<b>Environmental Health Consultation Response</b>		<b>Officer</b>	<b>Heather Barton</b>
<b>Detail: Tipi wedding venue to be used for half of each year</b>		<b>039658</b>	
<b>Address:</b>			 <p>Ribble Valley Borough Council</p> <p><a href="http://www.ribblevalley.gov.uk">www.ribblevalley.gov.uk</a></p>
<b>Application Ref:</b>	3/2018/0575	<b>Case Officer:</b> Mr Adam Birkett	
<b>Response Ref:</b>	3/2018/0575/ENV/01	<b>Issue Date:</b> 10 July 2018

Hawkshaw Farm
Wedding Tpees
Proposed Site Plan
Scale 1:1000 @ A3

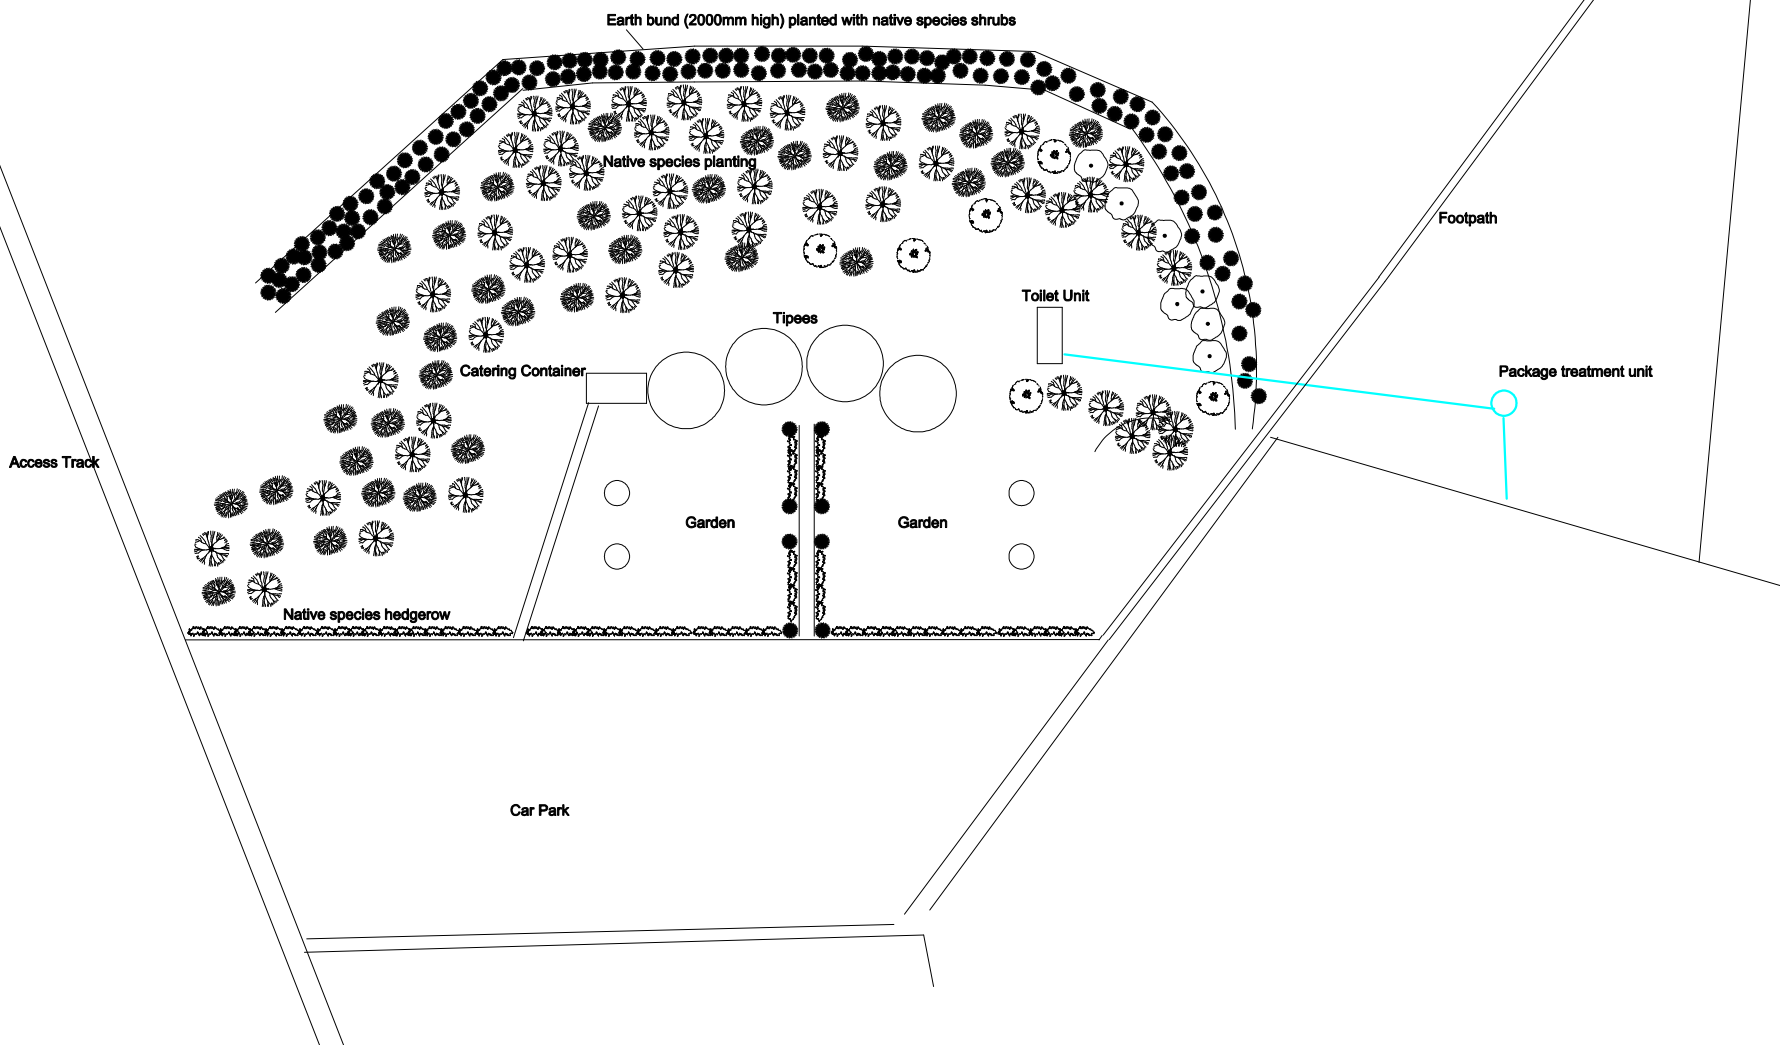
<b>General Comments/Observations</b>	
<b>1.1</b>	Noise impact assessment not submitted
<b>1.2</b>	Location of Tipi's is towards potential noise sensitive receptors
<b>1.3</b>	Lack of information provided with regards to control methods for noise from music / people and vehicles
<b>Suggestions/Mitigation</b>	
<b>2.1</b>	Submit a noise impact assessment for the site
<b>2.2</b>	Provide details of mitigation of noise from live music / disco/ people from the area
<b>2.3</b>	Provide details of specific times of operation
<b>Conclusions/Suggested Conditions</b>	
<b>2.4</b>	The above observations have been provided on the basis of the level of information submitted and the comments contained within this response represent officer opinion only, at the time of writing, without prejudice.
<b>Officer:</b>	
<b>Heather Barton</b>
